GRADING AND EROSION CONTROL PLAN CHECKLIST

Creekside South at Lorson Ranch Fil. No. 1

STORMWATER MANAGEMENT PLAN CHECKLIST

DATE: MAY 12, 2020
 PROJECT NO: 100.051
 SHEET NUMBER: C4.3
 TOTAL SHEETS: 15

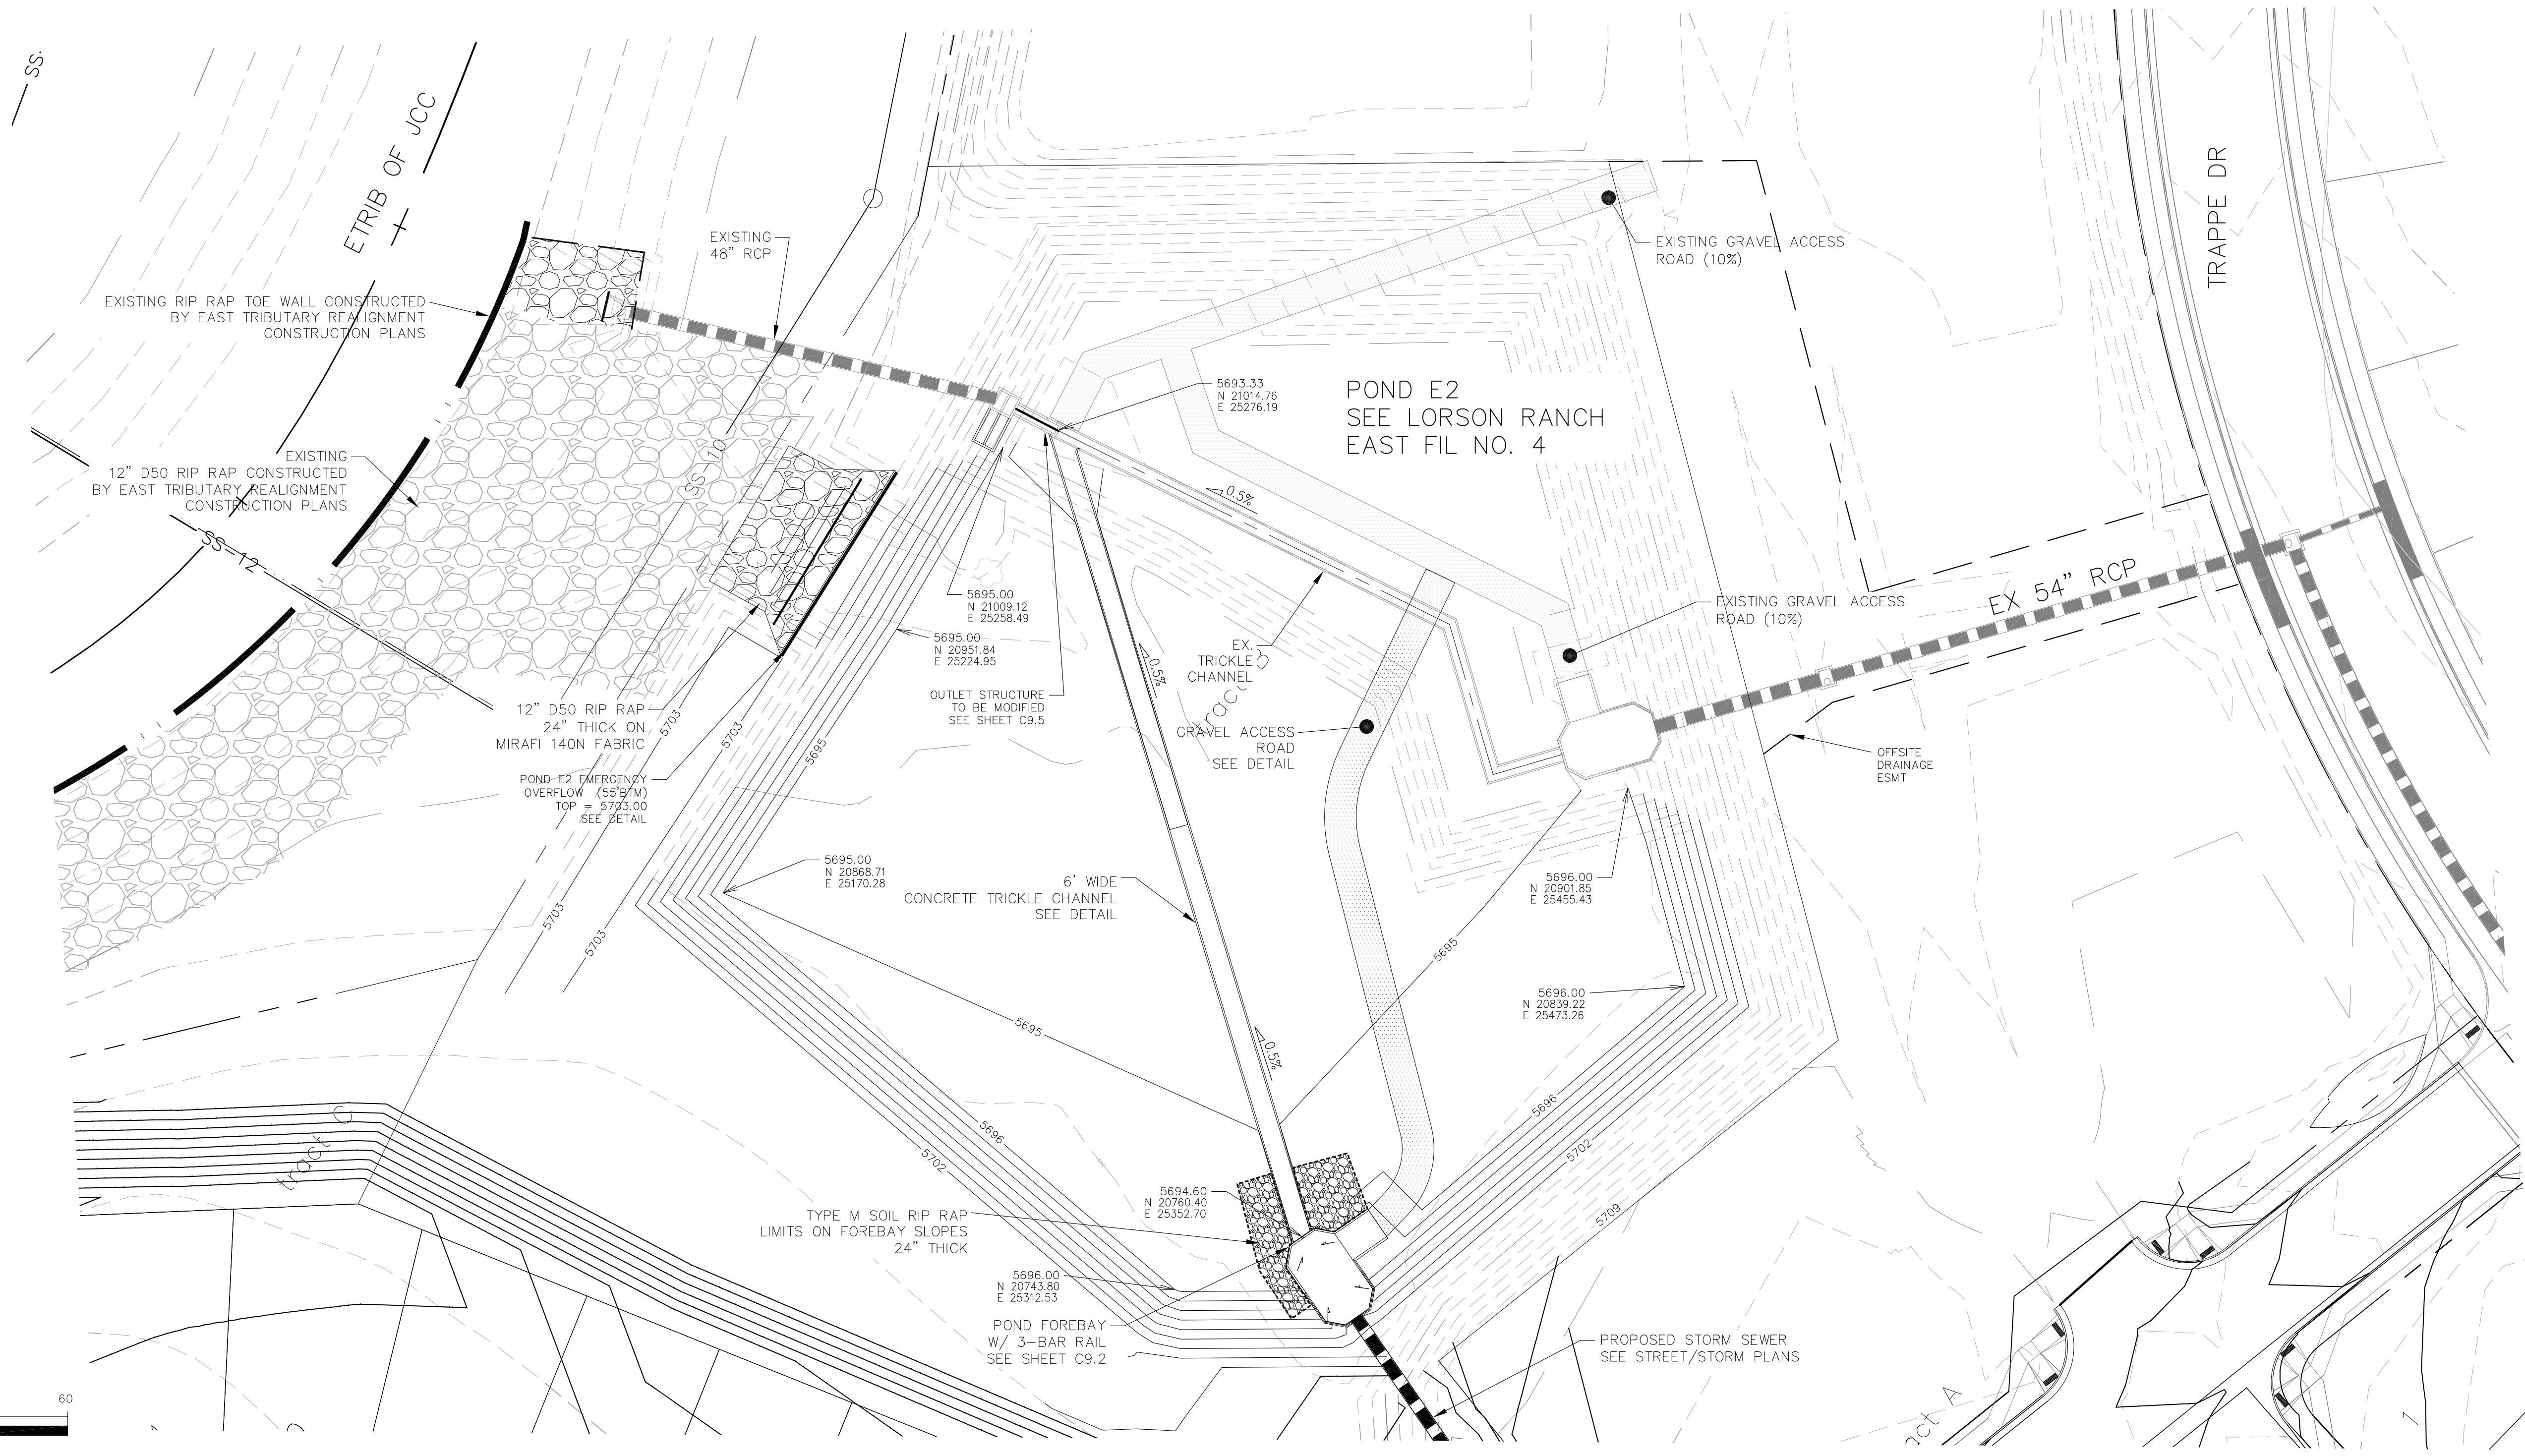
Applicant	PCD
1. GRADING AND EROSION CONTROL PLAN			
a	Vicinity map.	y	✓
b	Adjacent city/town/jurisdictional boundaries, subdivision names, and property parcel numbers labeled.	y	✓
c	North arrow and acceptable scale (1"=20' to 1"=100').	y	✓
d	Legend for all symbols used in the plan. Show ECB	y	✗
e	Existing and proposed property lines. Proposed subdivision boundary for subdivision projects.	y	✓
f	All existing structures.	y	✓
g	All existing utilities.	y	✓
h	Construction site boundaries.	y	✓
i	Existing vegetation (notes are acceptable in cases where there is no notable vegetation, only grasses/weeds, or site has already been stripped).	y	✓
j	FEMA 100-yr floodplain.	y	✓
k	Existing and proposed water courses including springs, streams, wetlands, detention ponds, stormwater quality structures, roadside ditches, irrigation ditches and other water surfaces. Show maintenance of pre-existing vegetation within 50 feet of a receiving water.	y	✓
